**City of
Doncaster
Council**

City of Doncaster Council's response to The Examining Authority's written questions and requests for information (ExQ2): Issued on 07 July 2026

Project: Tween Bridge Solar Farm (EN010148)

21st July 2026

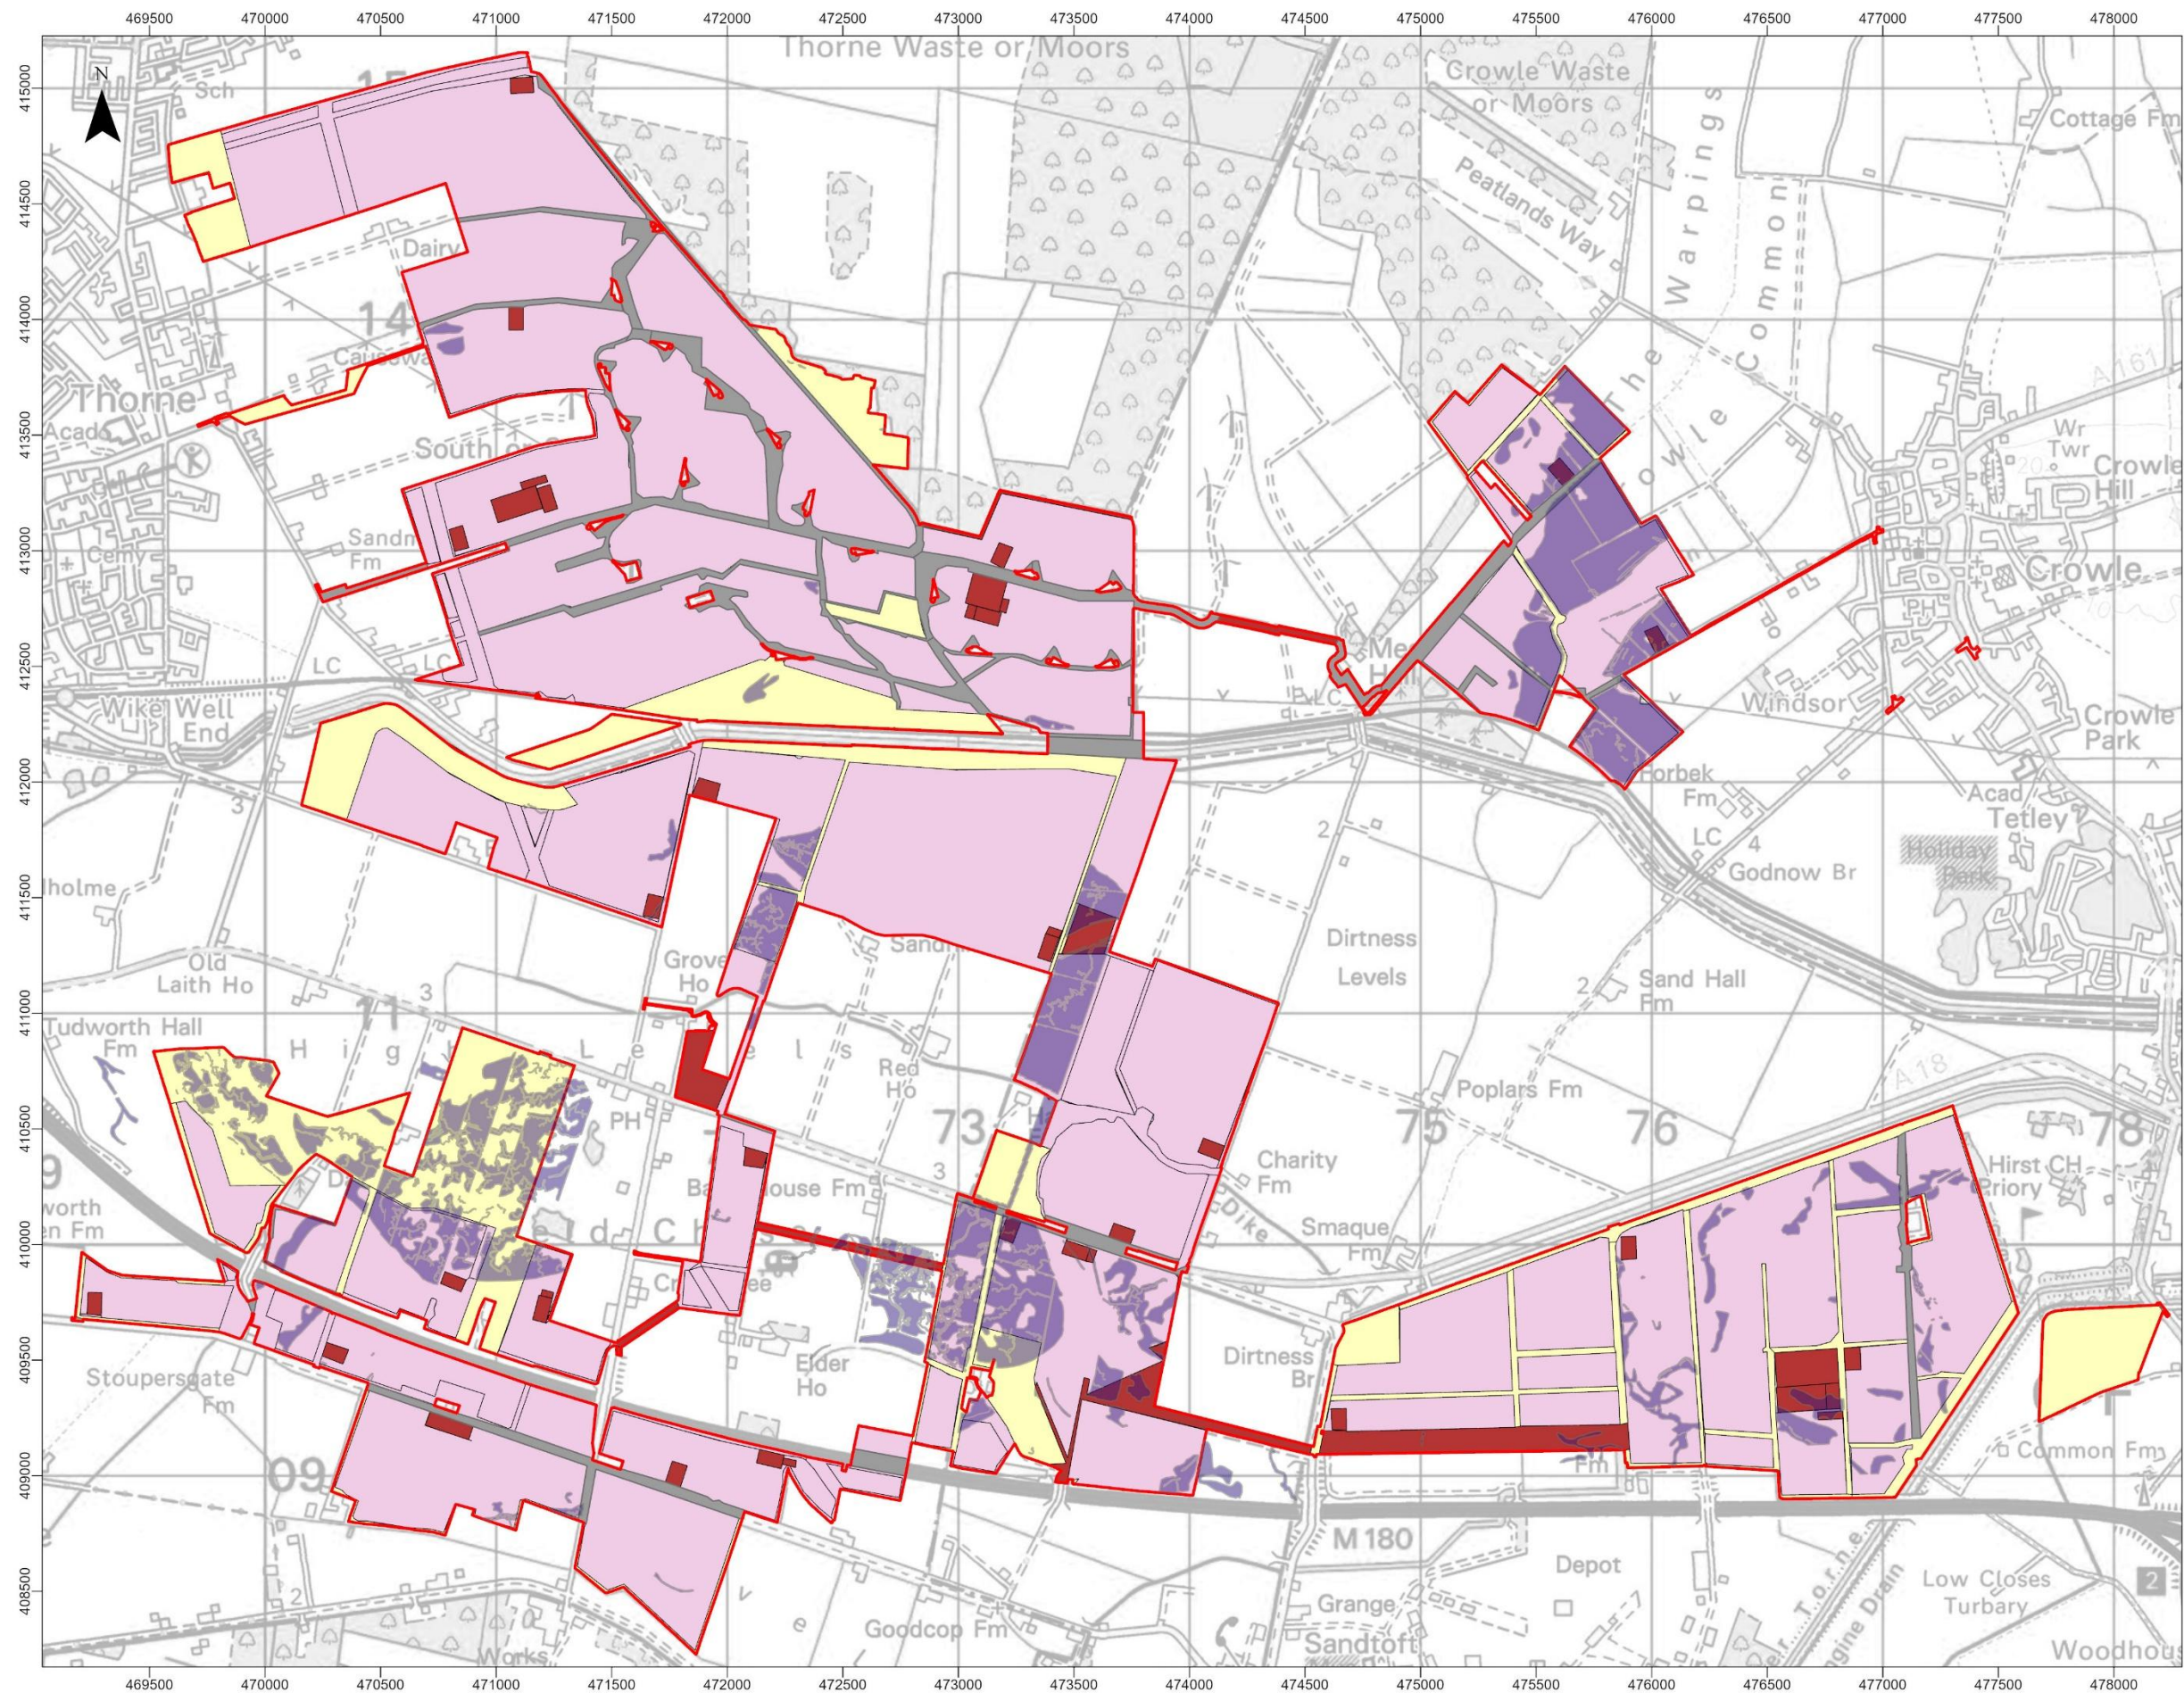
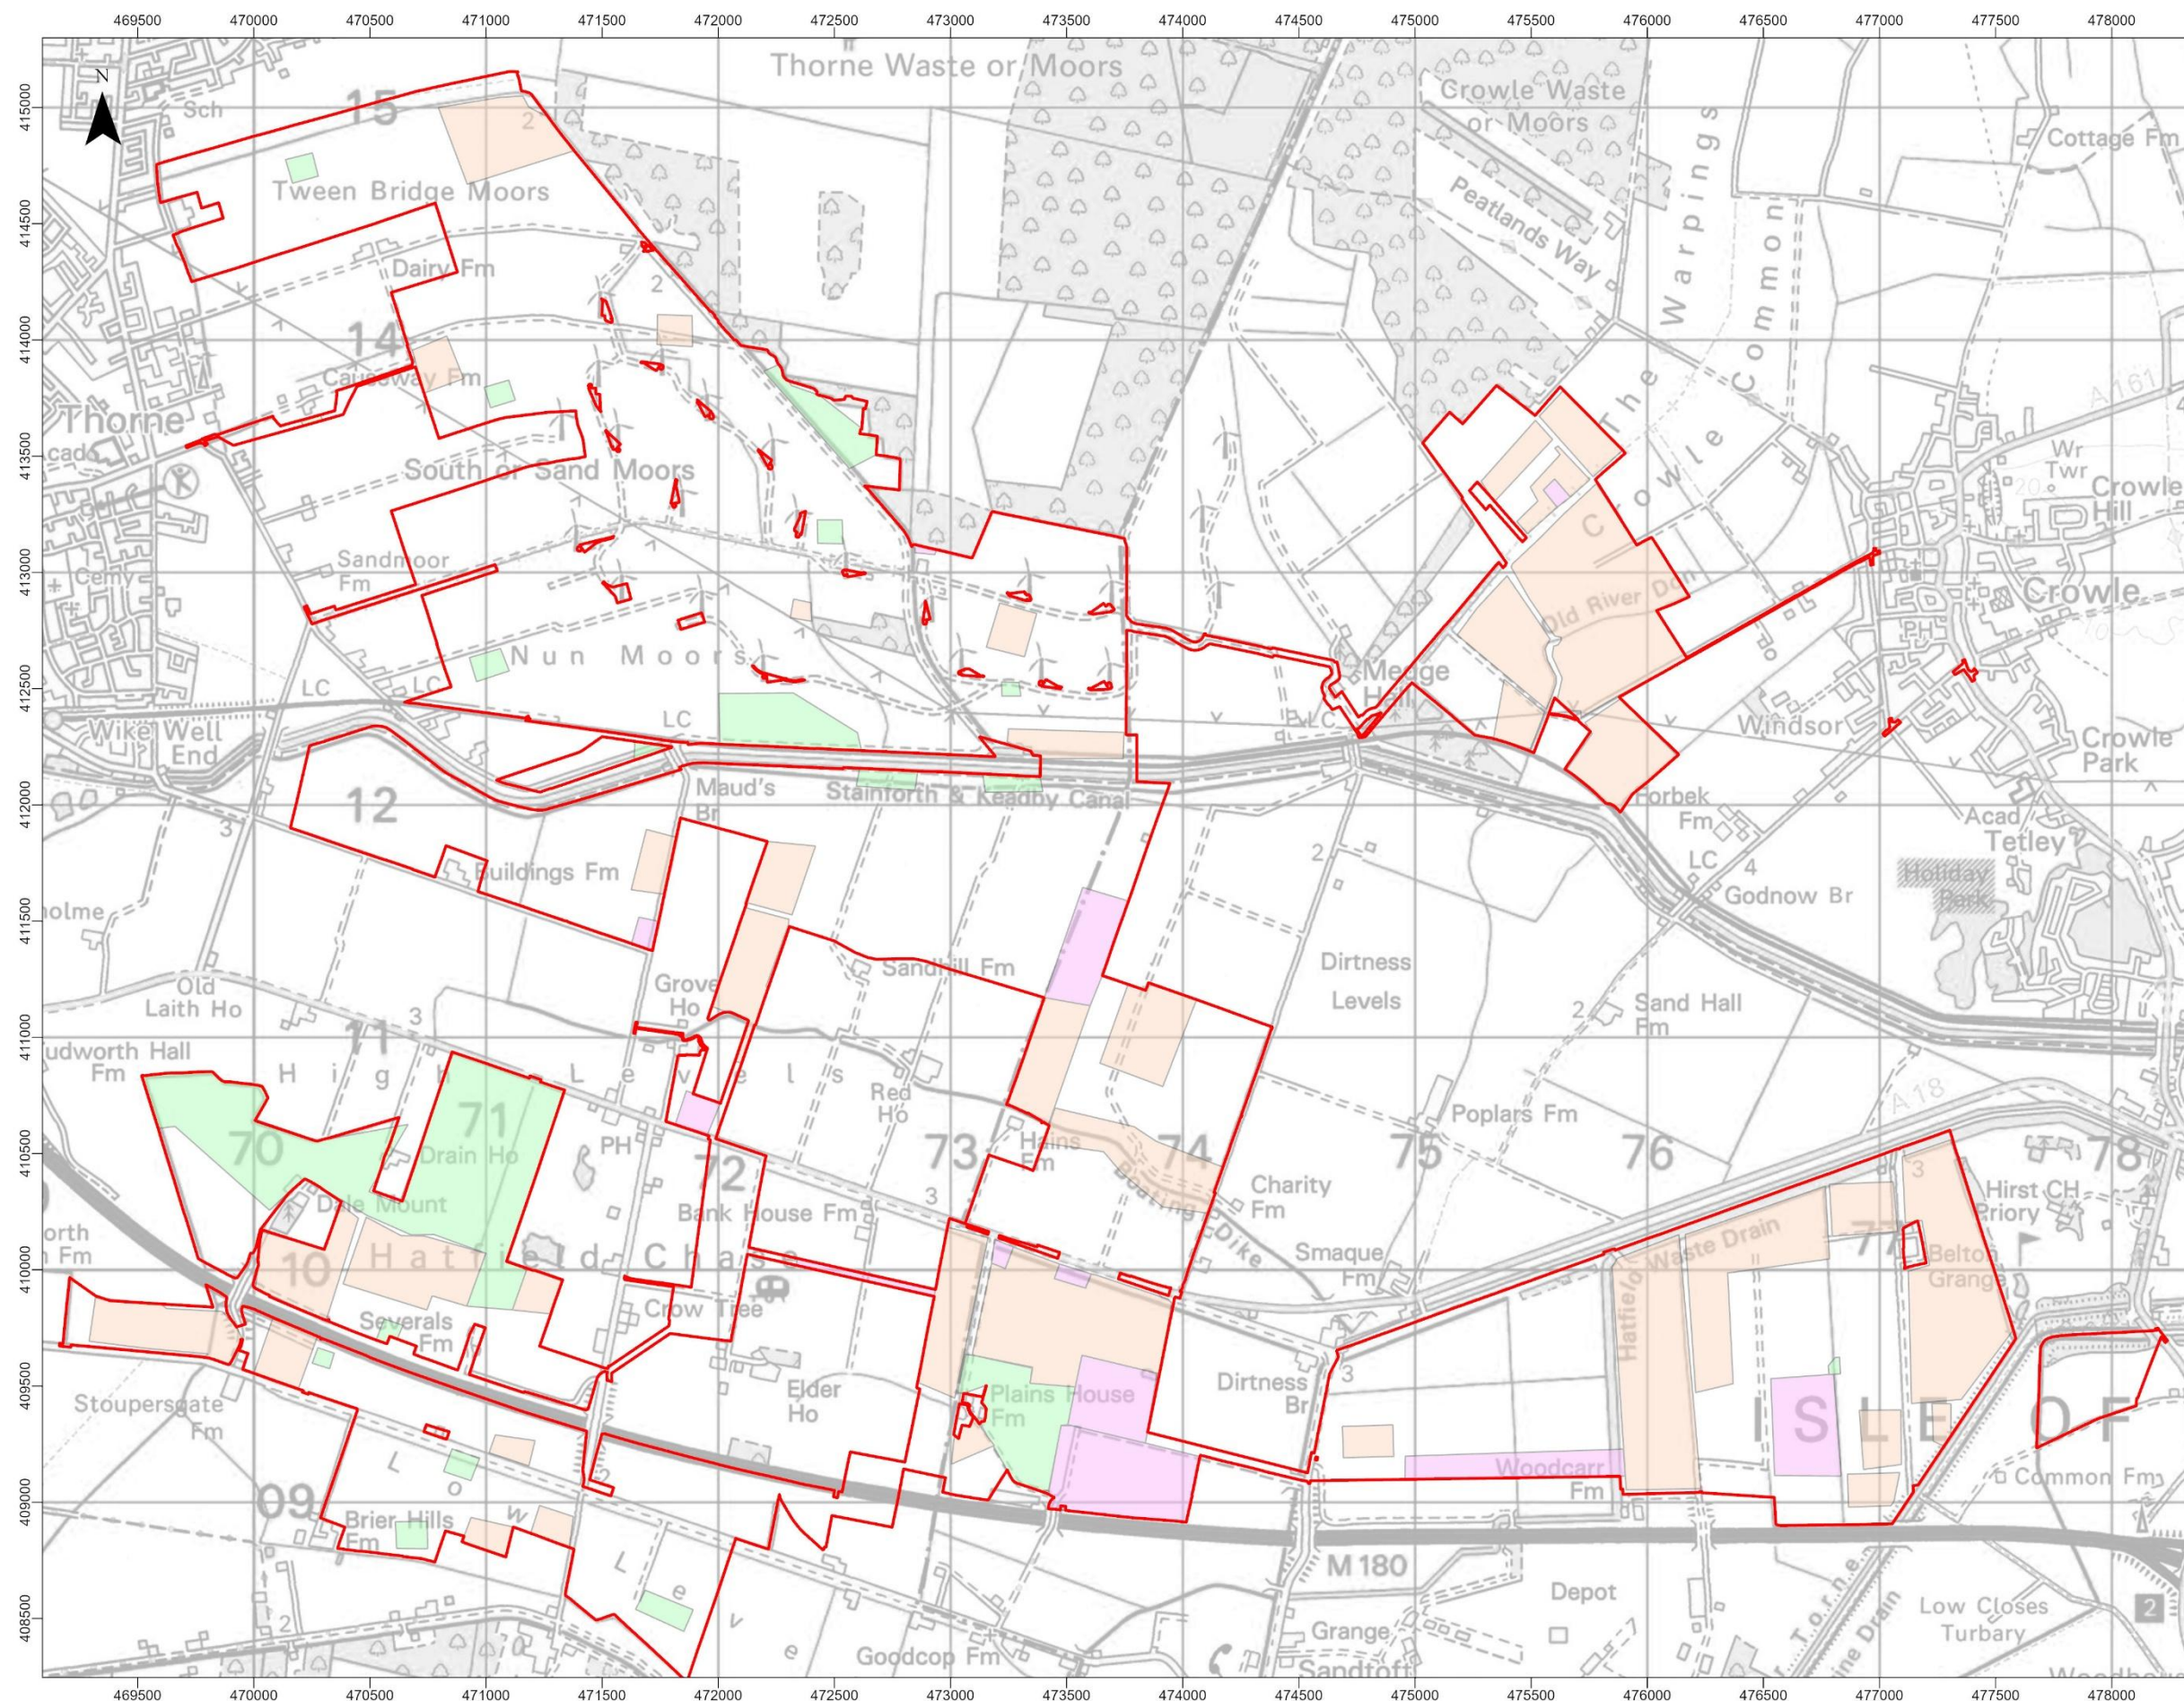
ExQ2	Question to:	Question:	CDC Response:
			archaeological remains are to be preserved in situ through the design of the scheme.
6. Cultural heritage			
Q2.6.3	CDC and the Applicant	Archaeology CDC's LIR [REP1-062] paragraph 8.30 states in part: 'In order for appropriate weight to be given to the effects of the proposals on the significance of any affected heritage assets, it will be necessary for the Applicant to demonstrate that sufficient flexibility remains within the scheme design and the mitigation options to respond to archaeological discoveries made and to avoid unnecessary harm.' Could CDC please elaborate and explain what this would look like in practice? Could the applicant also provide a response?	CDC's position, as set out in the LIR, is that sufficient weight can only be given to the potential effects on heritage assets where there is a clear understanding of both: • the likely archaeological significance of different parts of the Site; and • the extent to which individual scheme components can be modified or relocated in response to archaeological discoveries. While the Applicant has identified design flexibility as a characteristic of solar farm development, it is recognised that the degree of flexibility is not uniform across all elements of the scheme. Some components may be more constrained in their location or may result in greater levels of ground disturbance than others. CDC therefore considers that the Applicant should demonstrate how the anticipated archaeological significance of different areas relates to the flexibility available within the scheme design and how this relationship would inform the selection of appropriate mitigation measures should archaeological remains be identified. In practice, the datasets gathered for the heritage baseline suggest the varying archaeological sensitivities across the order limits. These can be used as a proxy for significance

ExQ2	Question to:	Question:	CDC Response:
			and, when mapped against the different impacts of the components of the scheme, produce a zoning plan which spatially defines the anticipated magnitude of effects. This spatial definition provides a mechanism for understanding the degree of design flexibility available within particular locations of the scheme and therefore the extent to which adverse effects on archaeological remains can be avoided through design changes or whether alternative mitigation measures would be necessary.
Q2.6.4	Applicant, CDC and NLC	Archaeology Could the applicant please provide a response to the assertions made at paragraphs 8.19 to 8.29 of CDC's LIR [REP1-062]? Specifically, could the applicant explain whether it considers that it has sufficiently taken a holistic approach to the consideration of below ground heritage assets and the extent to which they are likely to be present? Please could both Councils and the applicant also provide an update on discussions with regard to the extent of archaeological works to be secured post consent (in the event that consent is granted)? Any disagreement should be clearly explained with reasons given.	The broad framework for post-consent archaeological works is currently set out within the oAMS [REP2-045]. However, detailed discussions regarding the precise extent of archaeological works that may ultimately be required post-consent have not yet been concluded. Discussions between the Applicant, SYAS (on behalf of CDC) and NLC have instead focused on the development of the zoning plan as a means of understanding the varying archaeological sensitivities and potential impacts across the Order Limits, and thereby informing a proportionate approach to any future archaeological works. Following discussion at ISH2, the Applicant revised the zoning plan which had been submitted as part of the updated oAMS [REP2-045] to include two figures. Those figures were subsequently discussed at a meeting between the Applicant, SYAS and NLC. During that meeting, SYAS provided detailed comments regarding the incorporation of existing archaeological

ExQ2	Question to:	Question:	CDC Response:
			datasets and other baseline evidence, with the aim of enabling the zoning plan to better illustrate the varying potential magnitude of effect across the Order Limits. It was agreed that a further iteration of the zoning plan would be prepared and submitted at Deadline 5. Discussions regarding the detailed scope of post-consent archaeological works remain ongoing and will continue to be informed by the development of that zoning plan.
